CIMARRON-NORTHWEST INDUSTRIAL FILING NO. 4
A REPLAT OF A PORTION OF LOT 1, BLOCK 2 CIMARRON-NORTHEAST INDUSTRIAL NORTHWEST
LOCATED IN SECTION 6, TOWNSHIP 14 SOUTH, RANGE 65 WEST OF THE 6TH P.M.
EL PASO COUNTY, COLORADO
LOT 1 SCHLAUFMAN SUBDIVISION NO. 1., PLAT 12717

OWNER: SAVAGE DEVELOPMENT GROUP LLC
2454 WAYNOKA ROAD, COLORADO SPRINGS, COLORADO 80915

Markup Summary

SITE DEVELOPMENT PLAN CIMARRON-NORTHWEST INDUSTRIAL FILING NO. 4

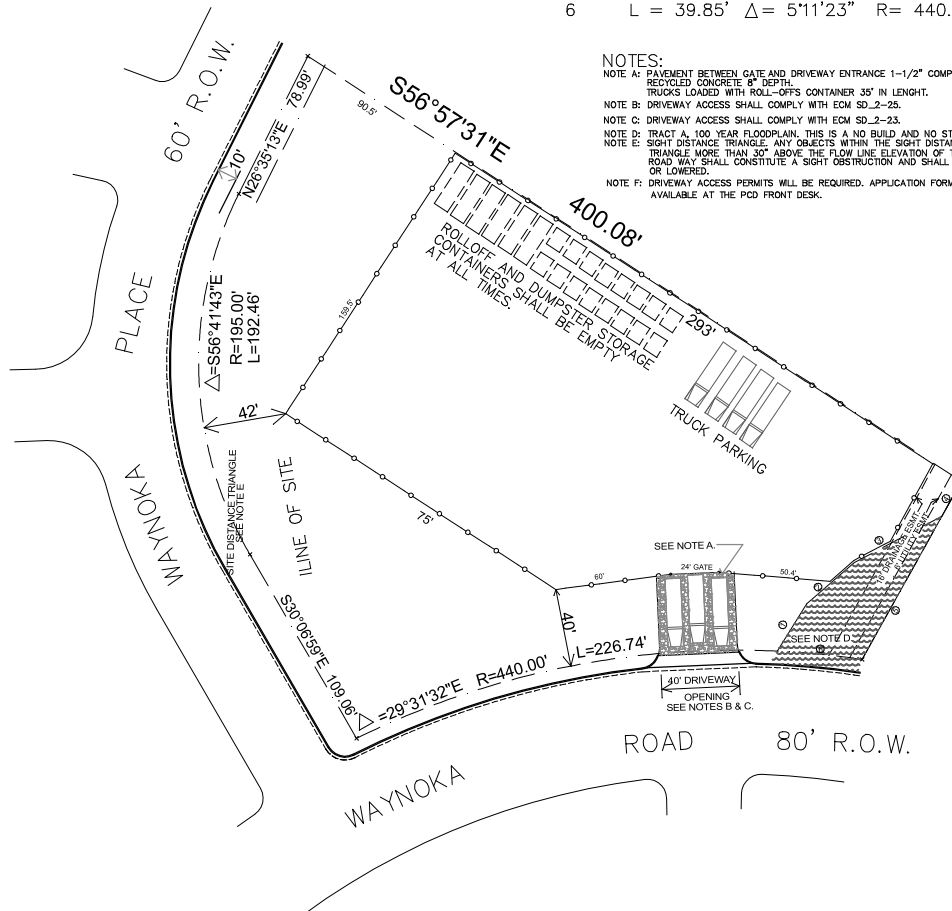
It appears that the access location does not meet the ECM criteria (Table 2-35) for sight distance to the north. Show the sight distance triangle to the north. Adjust the driveway location accordingly.

- Provide a callout referencing ECM Driveway detail SD_2-25.
- Show the line work for the driveway up to the fence

Add "Site Development Plan" to the title of the plan

Include details SD 2-25 and SD2-23 on the site plan.

- Indicate pavement at driveway leading to gate at both driveway locations.
- What is the max. length of truck with roll-off container? Verify that truck will not encroach into Waynoka Road while at the gate. Revise location of gate if necessary.

Provide legend for different line types used on plan.

Show where the equipment will be stored.

Show detailed parking area. Including how many spots are proposed.

Revise the bearings and distances information for the property lines and tract A (floodplain) to match the recorded plat.

Call out that the garbage containers will be empty at all times.

hatch this area and identify this as the "sight distance triangle" and add a note that says "any objects within the sight distance triangle more than 30" above the flow line elevation of the adjacent road way shall constitute a sight obstruction and shall be removed or lowered."

Use different line types to differentiate between curb/gutter & right-of-way, etc.

draw and label this line as a "line-of-sight"

Provide a callout referencing ECM Driveway detail SD_2-23

Label as Tract A 100 year floodplain and add note that this is a no-build & no-storage area.

According to the Assessor's website, this piece of the parcel is separate, and not in the same ownership as the subject lot.

Add "PCD File No.: PPR1832"
